2023/0871

Unit A, Priory Arms, Rotherham Road, Cundy Cross, Barnsley, S71 5RF

Installation of 1 x 48 sheet free-standing LED illumination advertising display panel (measuring 6.2M wide x 3.2M high and comprising metal frame and sealed LED screen).

BPC1 Site Plan

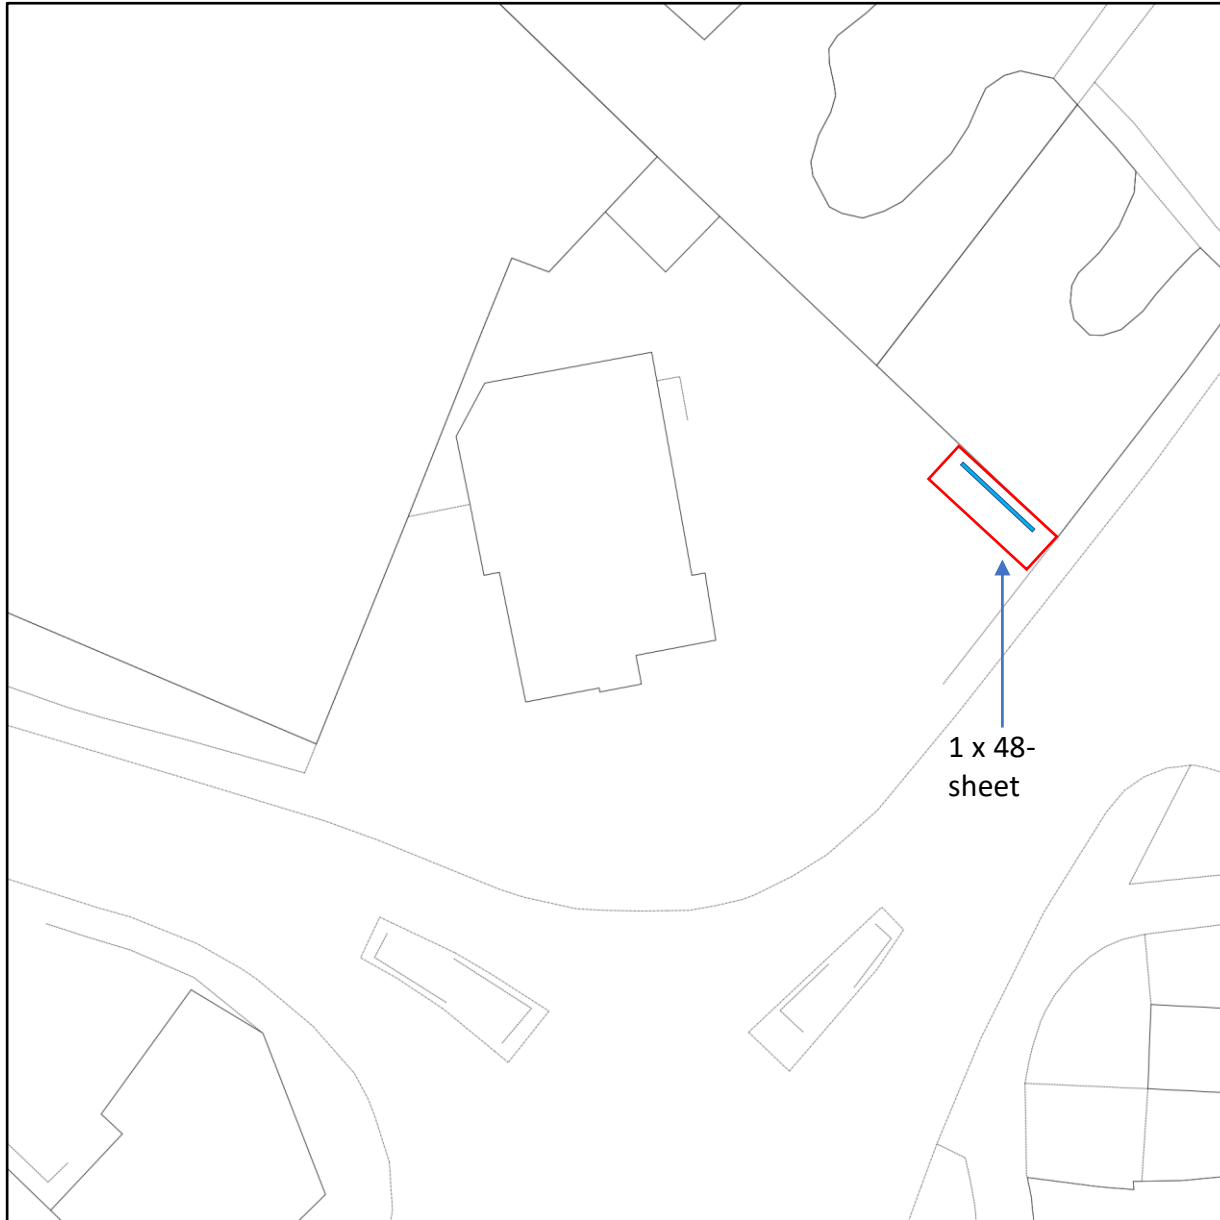
The proposed digital display advertisement would be located to the north-east boundary of a car park serving a two-storey building – formerly the Priory Arms public house – comprising ground floor commercial uses and first-floor flats. Some disturbance to residential properties arising from the illumination of existing lighting structures, signage, and digital display advertisements, and passing traffic, street lighting, and the static illumination of other commercial premises should be expected, especially in the context of their proximity to the major crossroads junction intersecting Pontefract Road, Rotherham Road, and Grange Lane, and the character of the surrounding area which comprises a mix of commercial and residential uses. However, due to the positioning of the former Priory Arms public house within its plot in relation to the location and orientation of the proposed advertisement (approximately 19 metres away), it is considered that the proposal would result in an unacceptable increase of light pollution that could impact habitable room windows located on the east elevation of the building that serve Flat 3 (as shown on the approved plans of planning application 2011/1483) and therefore, likely to exacerbate the existing level of impact to the detriment of the amenity currently afforded to this property.

In the opinion of the Local Planning Authority, the proposed advertisement would result in an unacceptable increase of light pollution that would adversely impact the first-floor habitable room window(s) of flat 3 located on the east elevation of the former Priory Arms public house, and is therefore, in conflict with Local Plan Policy GD1: General Development and Local Plan Policy POLL1: Pollution Control and Protection.

In the opinion of the Local Planning Authority, the proposed advertisement would adversely impact highway safety due to its size, siting, and interaction with highway users travelling north-east along Pontefract Road (A628) and those that may be slowing or may have stopped in order to turn right onto Lang Avenue. The proposal is therefore, considered to harm the safe, secure, and convenient access and movement of highway users and is therefore, in conflict with Local Plan Policy T4: New Development and Transport Safety.

In the opinion of the Local Planning Authority, the proposed advertisement would materially harm the appearance of the street scene by reason of its size, siting and undue prominence that would result in the over-commercialisation and dominance of the locality, and is therefore, in conflict with Local Plan Policy D1: High Quality Design and Place Making and the Supplementary Planning Document: Advertisements.
